18 April 2013

**The Department of Planning & Infrastructure  
GPO Box 39  
SYDNEY NSW 2001**

**Submission in Response to the EIS on the proposed Nyngan Solar Plant  
(Application Reference Number SSD-5355)**

APPENDIX E INDICATIVE INFRASTRUCTURE LAYOUT

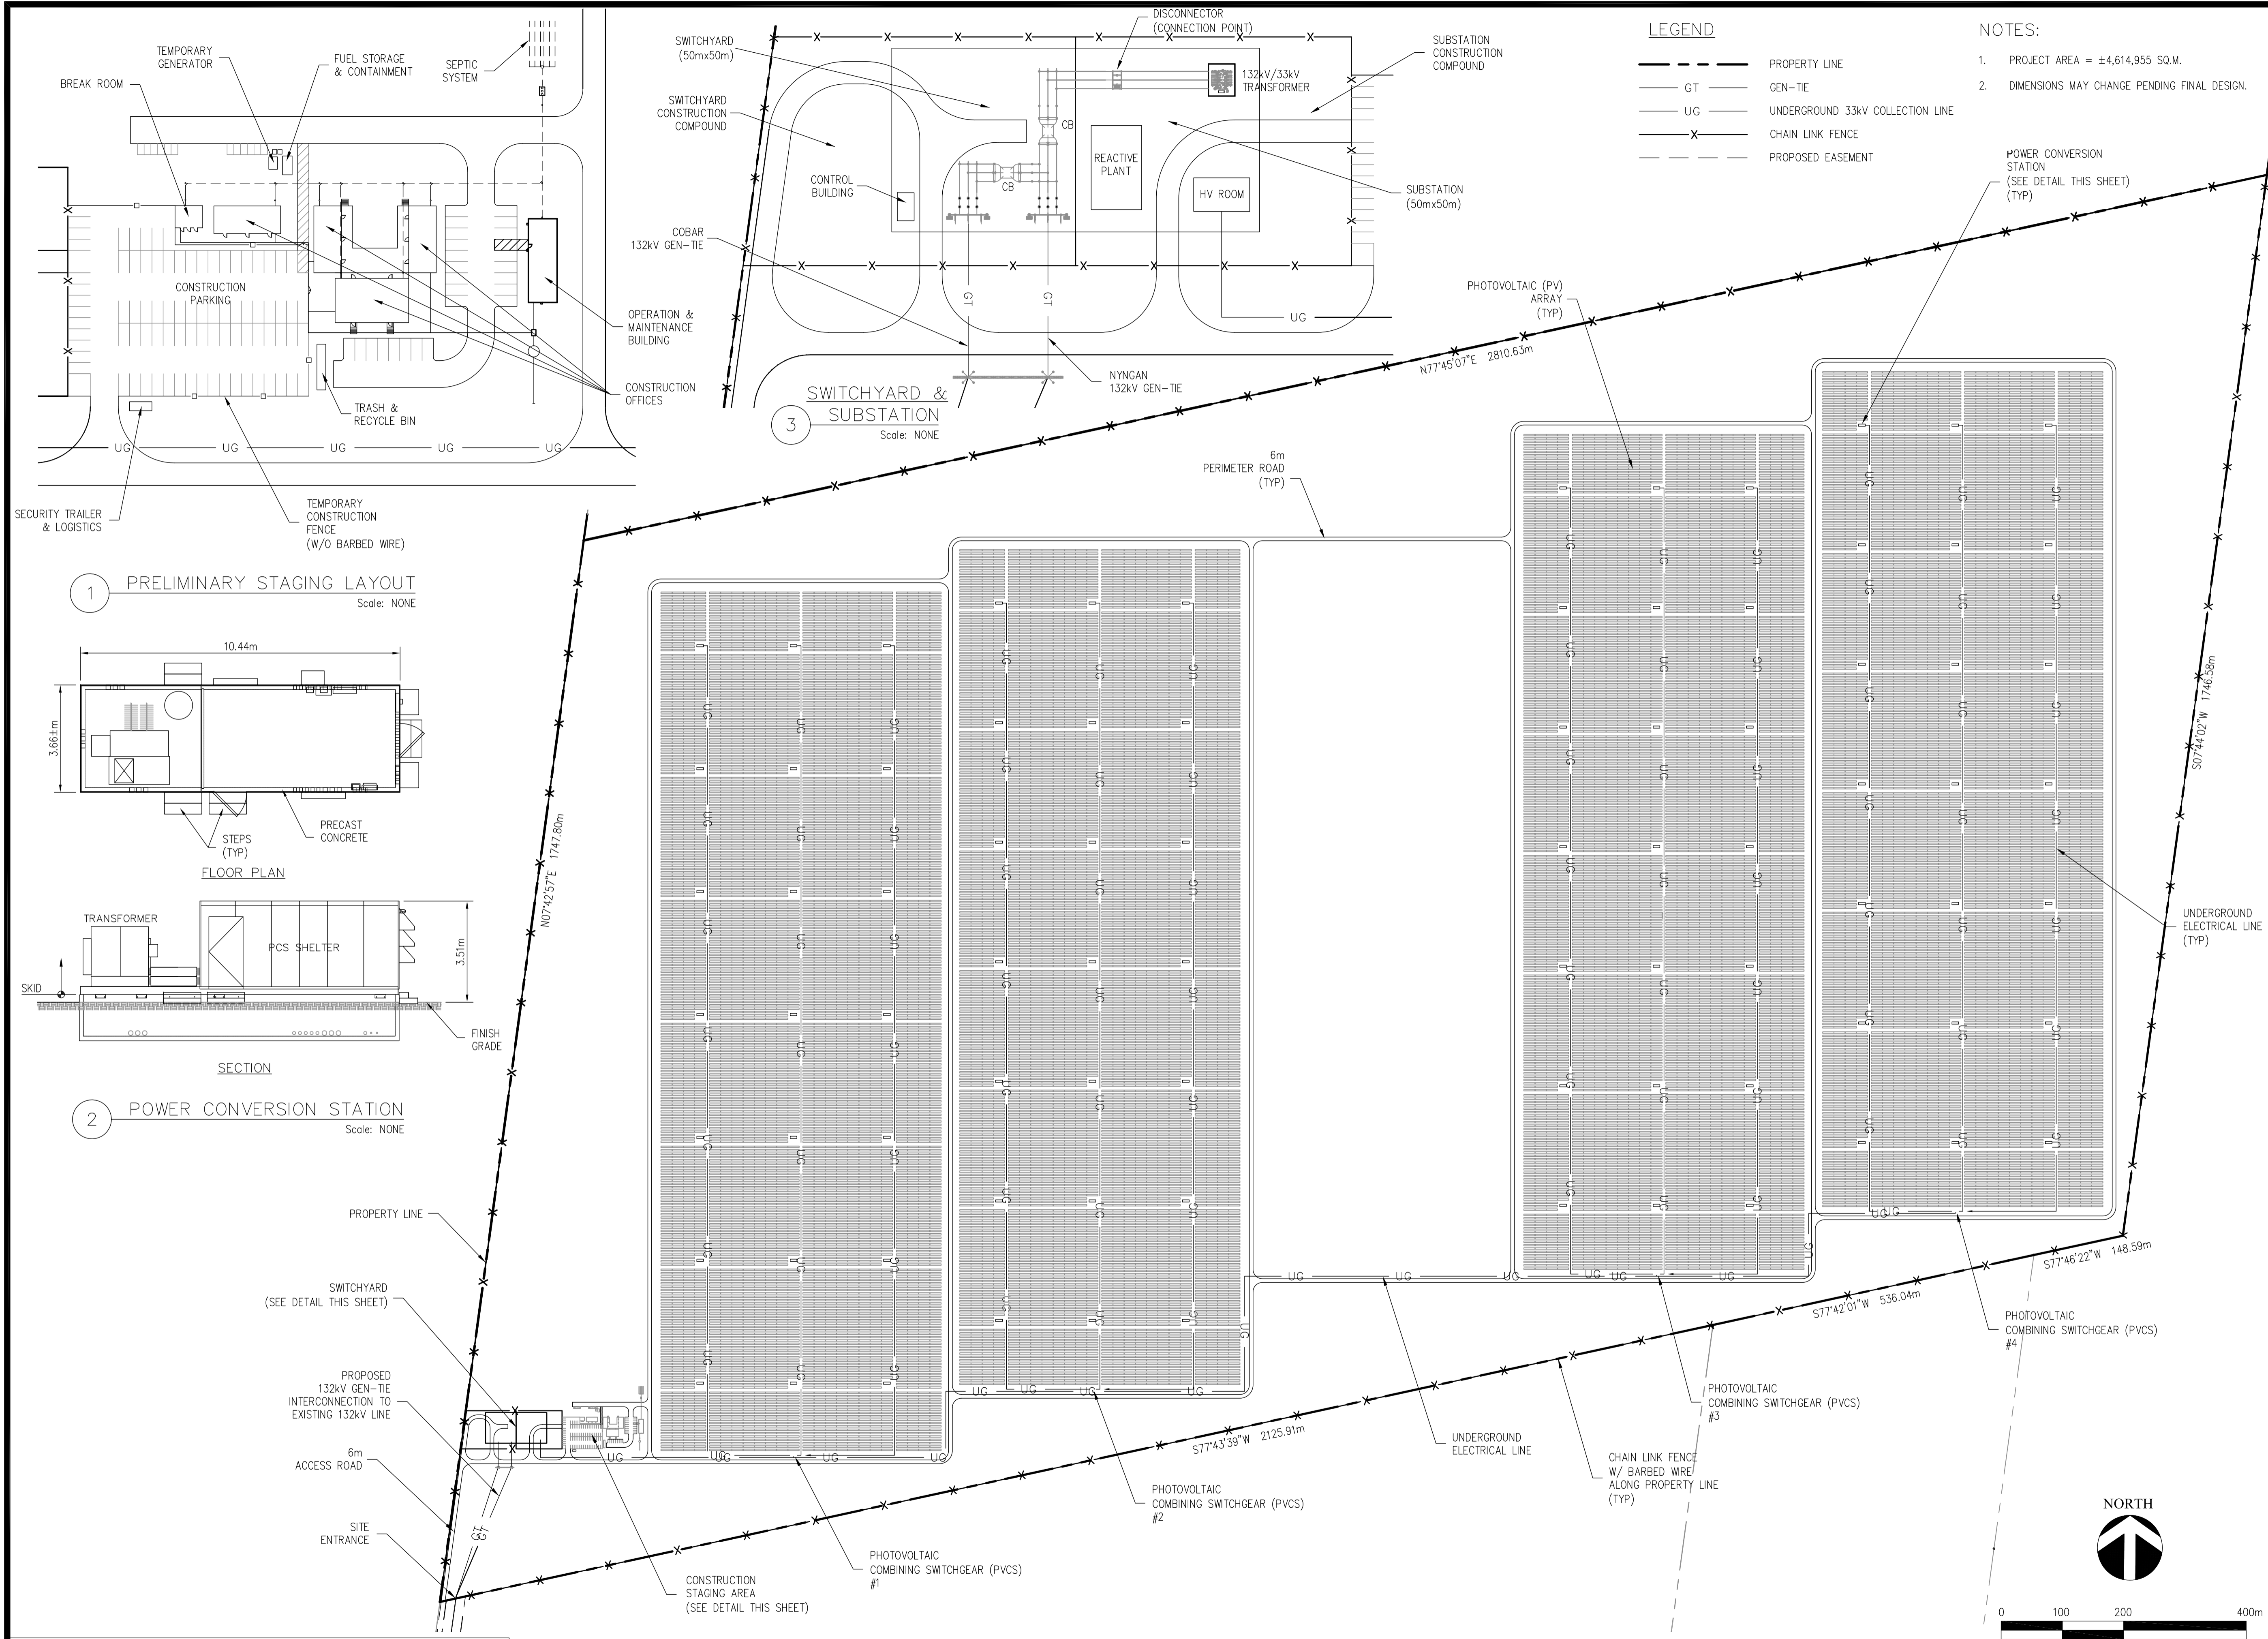
In Council's view the intersection of the facility access road and the Barrier Highway, managed by the RMS, should be upgraded to appropriate Austroad design standards that will accommodate the peak construction traffic, including 30 heavy vehicles per day and at least 80 cars and say 20 buses. Such upgrading should include wide bitumen sealed shoulders for 50 m and acceleration and deceleration lanes.

The Proponent proposes a 6 m wide unsealed, gravel access road. Being unsealed, there is a significant risk that during wet weather and after rain mud from the construction site will be trafficked onto the Barrier Highway, posing a hazard to fast moving traffic. In dry weather, particularly during construction, there is a risk of significant quantities of dust being blown across the Barrier Highway. It is recommended that the access road be constructed with a minimum 150mm thick crushed rock pavement and bitumen sealed for a sufficient distance from the Barrier Highway to prevent mud, gravel, and dirt being dropped onto the highway.
